WEST SUSSEX COUNTY COUNCIL CONSULTATION

TO:	Arun District Council FAO: Simon Davis
FROM:	WSCC – Highways Authority
DATE:	4 December 2024
LOCATION:	Land west of Pagham Road Pagham
SUBJECT:	P/114/24/RES Reserved matters application (pursuant to outline permission P/178/21/OUT (APP/C3810/W/22/3302023)) for matters of appearance, landscaping, layout and scale concerning the construction of 95 new homes along with new pedestrian and cycle links, open space, landscaping, habitat creation, drainage features and associated groundworks and infrastructure. This development is in CIL zone 5 (CIL liable as new dwellings) and may affect the setting of listed buildings.
DATE OF SITE VISIT:	n/
RECOMMENDATION:	Advice

1. Comments are made in respects of,
 - Site Layout, drawing number SL01, revision A
 - Road Widths Around Site, drawing number MBSK241016-02, revision P3

Client Bargate Homes
 Job no. BARG230419
 Dwg no. SL.01
 Author CMI Checked -
 Status PLANNING Scale 1:500 at A1
 Client ref. Office Romsey

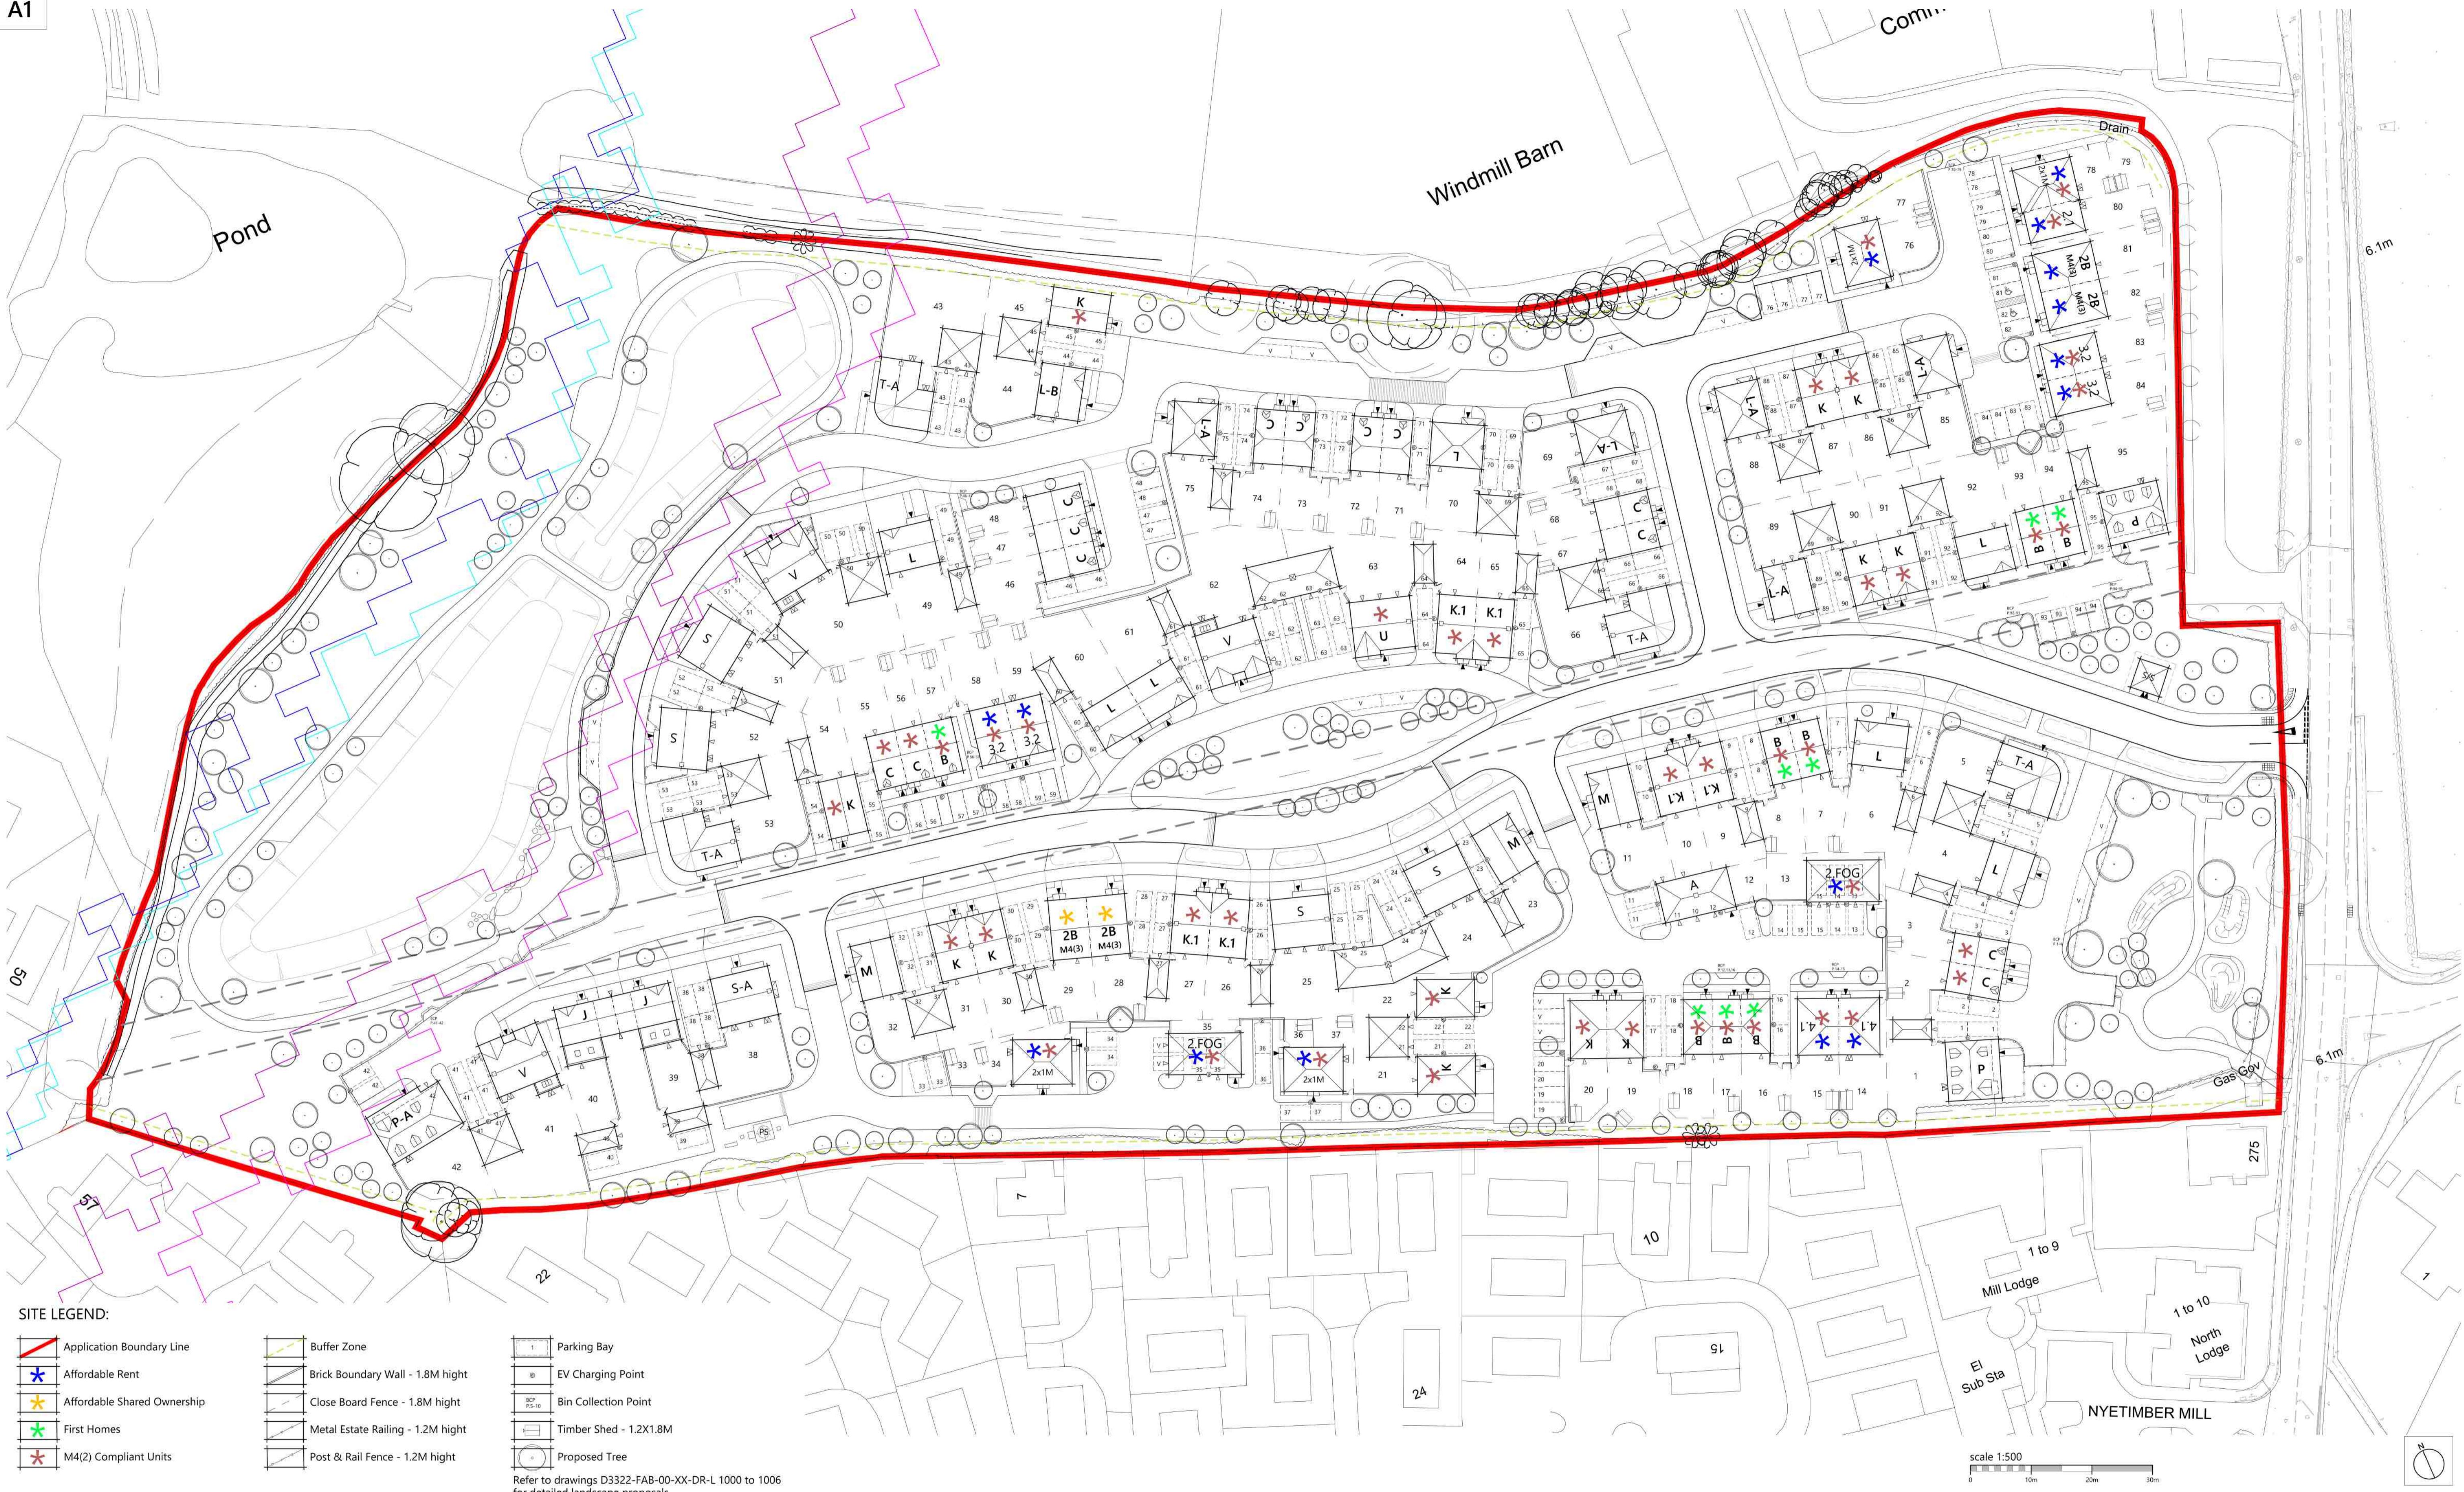
Whilst WSCC have no particular concerns with the general principles shown, the inclusion of the short length of shared surface on the main access road does seem at odds with the remainder of the development with it unclear why pedestrians elsewhere are provided with a footway but this is deemed unnecessary in this situation. For partially sighted pedestrians, the arrangement shown is not especially logical. WSCC preference would be to continue the footway across the frontages of plots 70 to 75.

4. It would also be highlighted that shared surface areas should be built in a contrasting material to areas of segregated footway and carriageways. There is contradicting information in these respects shown on the 'Colour Landscape Masterplan' and the 'Site Layout'; one drawing shows the use of a contrasting material whereas the other shows surfacing comparable to the standard segregated footway/carriageway construction. The drawings should be consistent.

5. The road narrowing in front of plots 71 and 72 would serve no additional purpose beyond that already achieved through the existing road layout. The narrowing would only otherwise restrict access to the driveway for plot 71. It's recommended that the narrowing is removed.

6. The exact nature of the area proposed on the opposite side of the access to plots 39 and 40 is unclear. The 'Colour Landscape Masterplan' shows this area in a different material with what appears to be a bench and fencing alongside the carriageway edge. WSCC preference would be for this area to be of typical footway construction as found elsewhere within the development. The features shown within this area can then be positioned outside of any highway areas. WSCC would flag this as the introduction of non-standard features may complicate the adoption process.

7. WSCC would also strongly recommend that the fencing shown on the 'Colour Landscape Masterplan' that extends all the around the perimeter of the landscaped area is setback and positioned a minimum of 450 mm back from the carriageway edge. This will then avoid the fencing being struck by vehicles. Also any gates within the fencing should provide a waiting areas for pedestrians to stand clear of the live carriageway whilst opening the gates.

8. The visitor parking bays opposite plots 69 and 88 should be 6 metres long. The lengths as presented are substandard meaning these bays will be unusable by the majority of vehicles.

9. A detailed breakdown will be required to show the parking provision complies with the adopted Arun District Council parking standards. As an observation, there doesn't appear to be any great number of visitor parking spaces. Visitor parking bays should be designed to be accessible by disabled persons (i.e. be of suitable width and have a hard margin rather than vehicle occupants exiting onto grass).

10. As a general comment, the highway alignment to the north of plot 75 is quite severe and not ideal. Intervisibility between two opposing vehicles would be quite limited. Vehicles passing through this bend would not in practice be tight to the kerb but likely taking a more central position in the carriageway. Vehicle speeds would be low passing through this but it would be desirable for the alignment to be altered.

11. Pedestrian crossing points with tactile paving should be provided at all junctions and potential crossing locations.
12. Clarification would be sought from the Applicant on the above points.
